Re: Planning Application 18/0372

Address: Playing Field Edisford Road Clitheroe BB7 3LA

Description: Creation of new artificial grass pitch (AGP) and refurbishment of existing multi use sports area with associated fencing, floodlighting, access pathways and storage units.

TITLE
Roefield Sports Pitches
Artificial Turf Pitch
Proposed AGP Plan

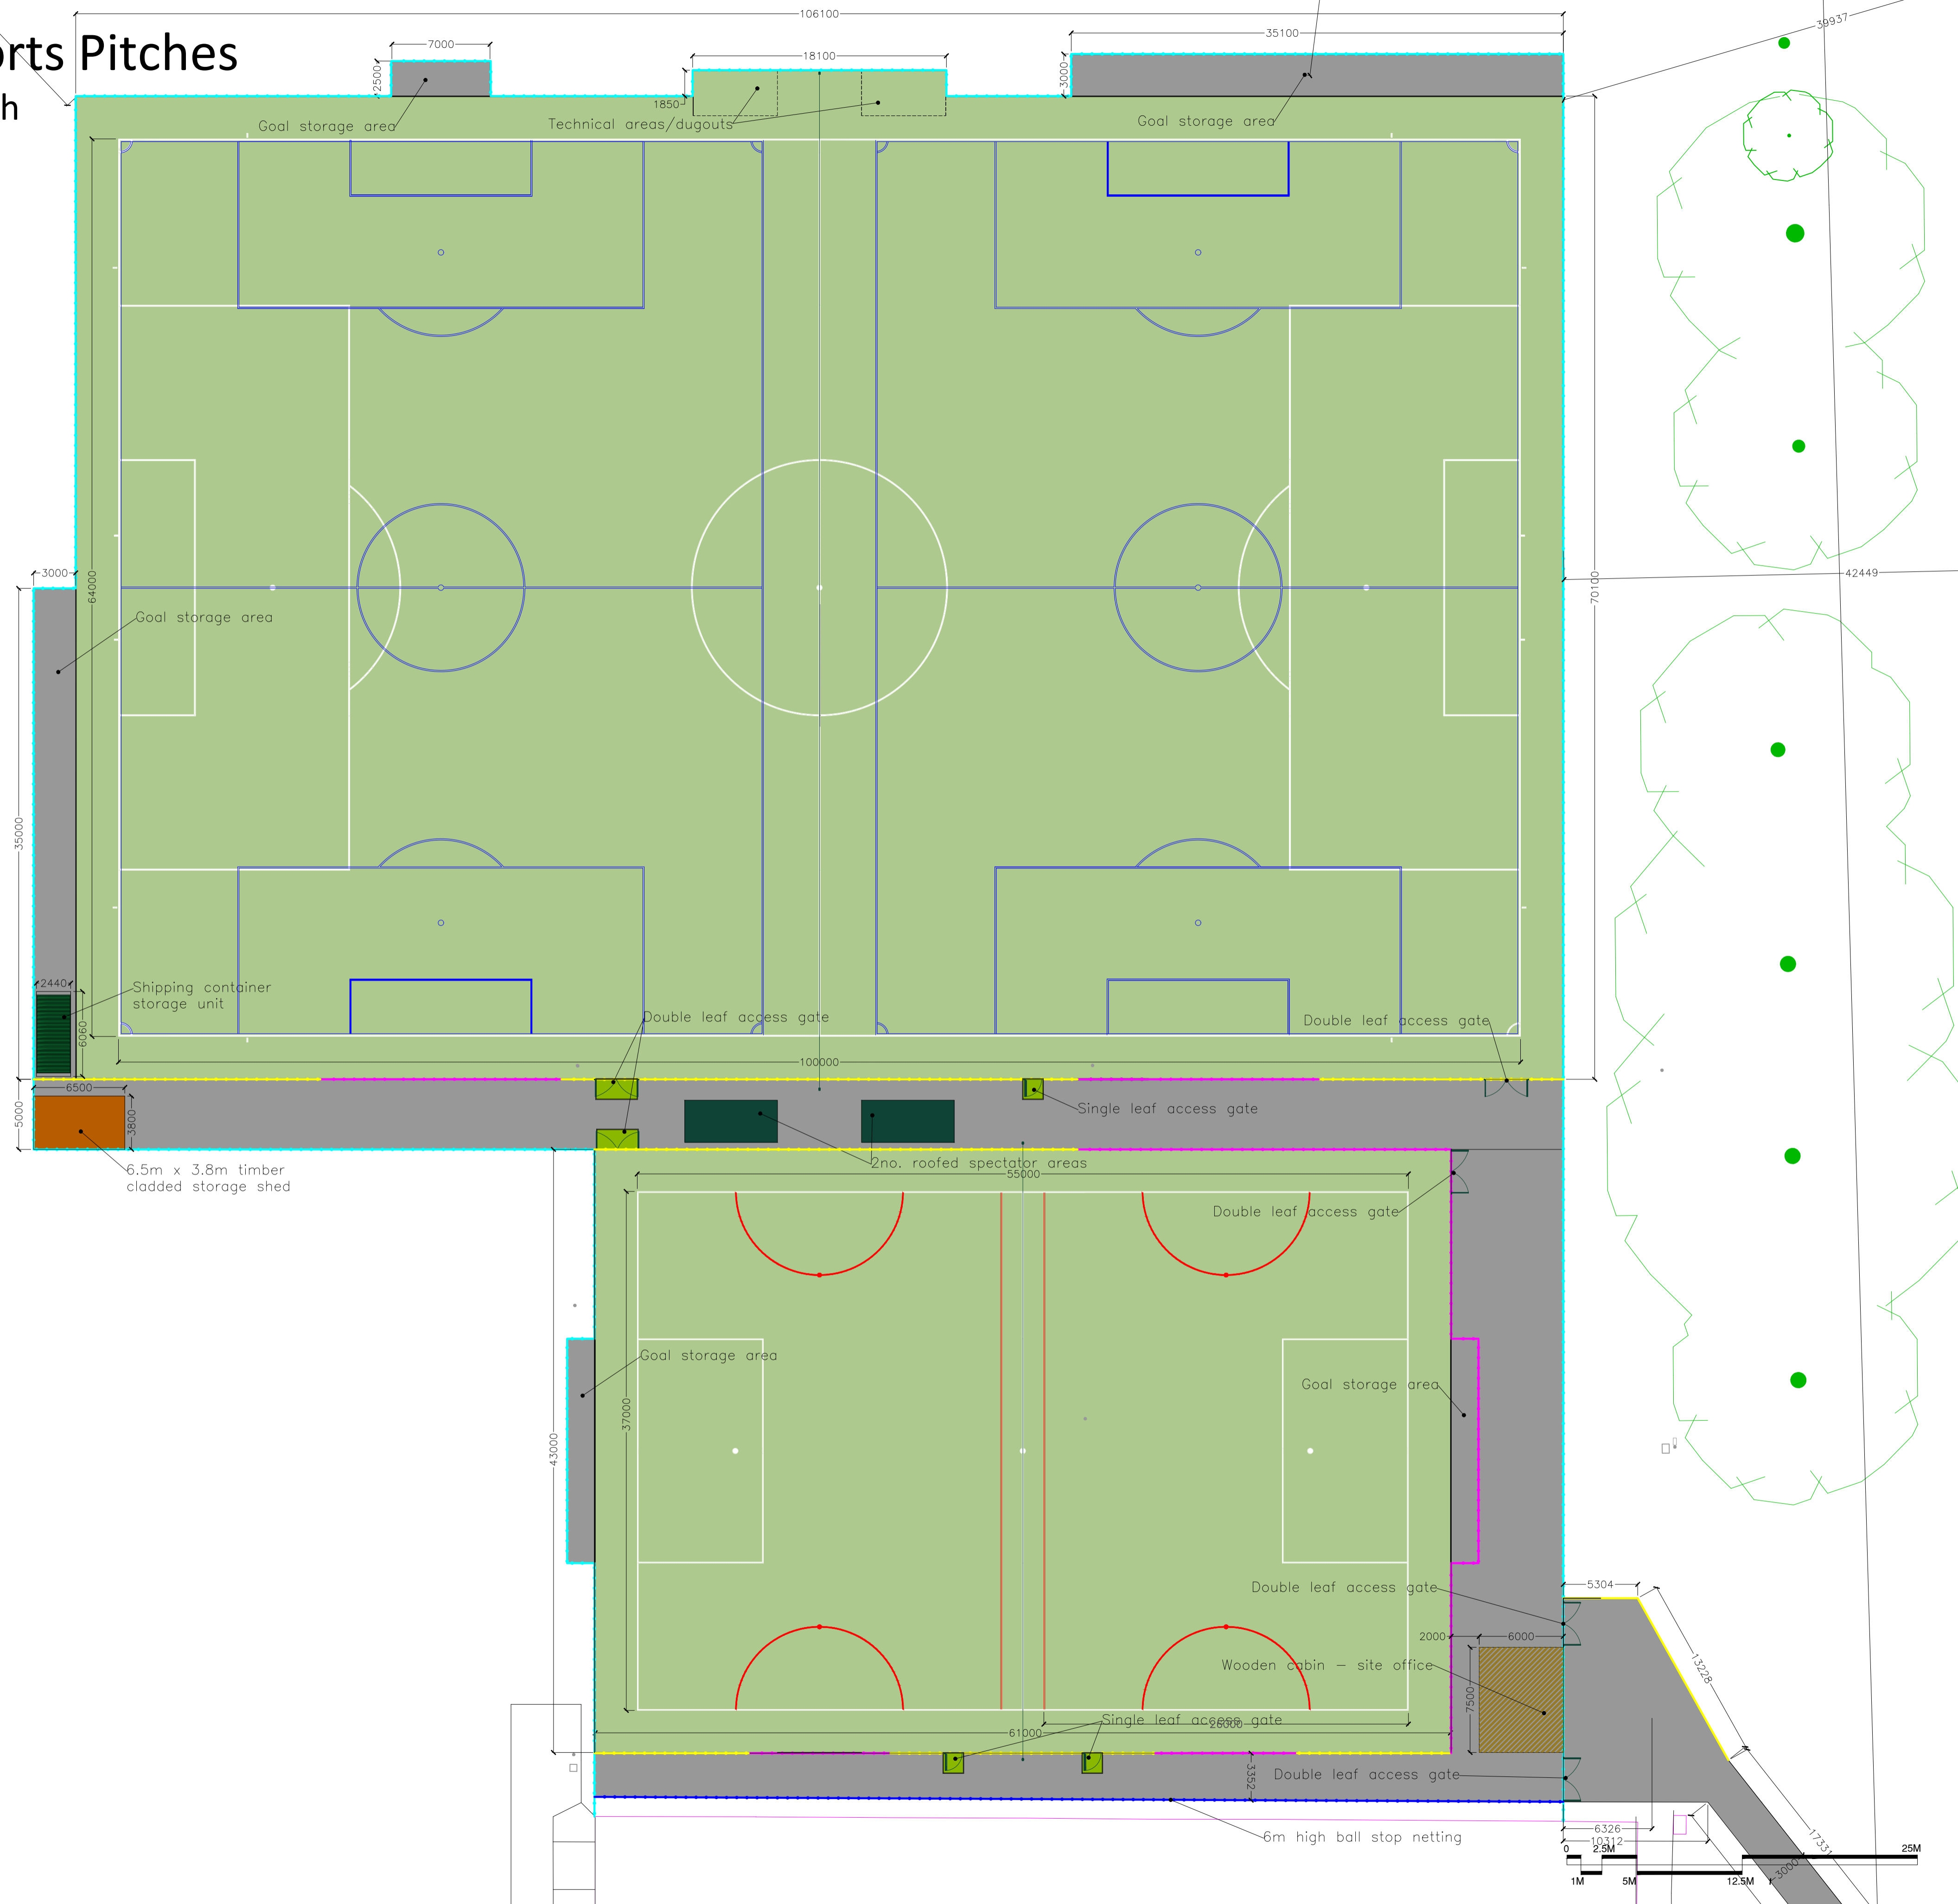
There are two footpath to be constructed from the new playing area back towards the car park. The wider path appears to be to improve the desire line, via an old gate in the wall, which then goes diagonally across to the end of the existing pedestrian barrier on the opposite side of the road. This is the shortest route back to the car park and is used by predominantly youths and adults, rather than accompanied children. This desire line was also shown to be the wider footpath back towards the car park, thus sub-consciously indicating that this is the preferred route. This lead to the request for the provision of some additional guard rail as part of some other highway works at the vehicle entrance to the car park.

If the applicant is unwilling to support the provision of pedestrian guard rail then we would strongly suggest that some sort of obstruction by way of a gaggle gate or Zig Zag gate is placed with-in the curtilage of the proposed development.

A further observation not commented by the applicant was the suggestion that the gate be filled in to match the existing wall, thus making the desire line less desirable as the wall would then have to be scaled. This would by inference mean that the other path shown back towards the car park nearer the Pelican Crossing may need to be widened, however this additional cost would be offset by the need to only lay one new path.
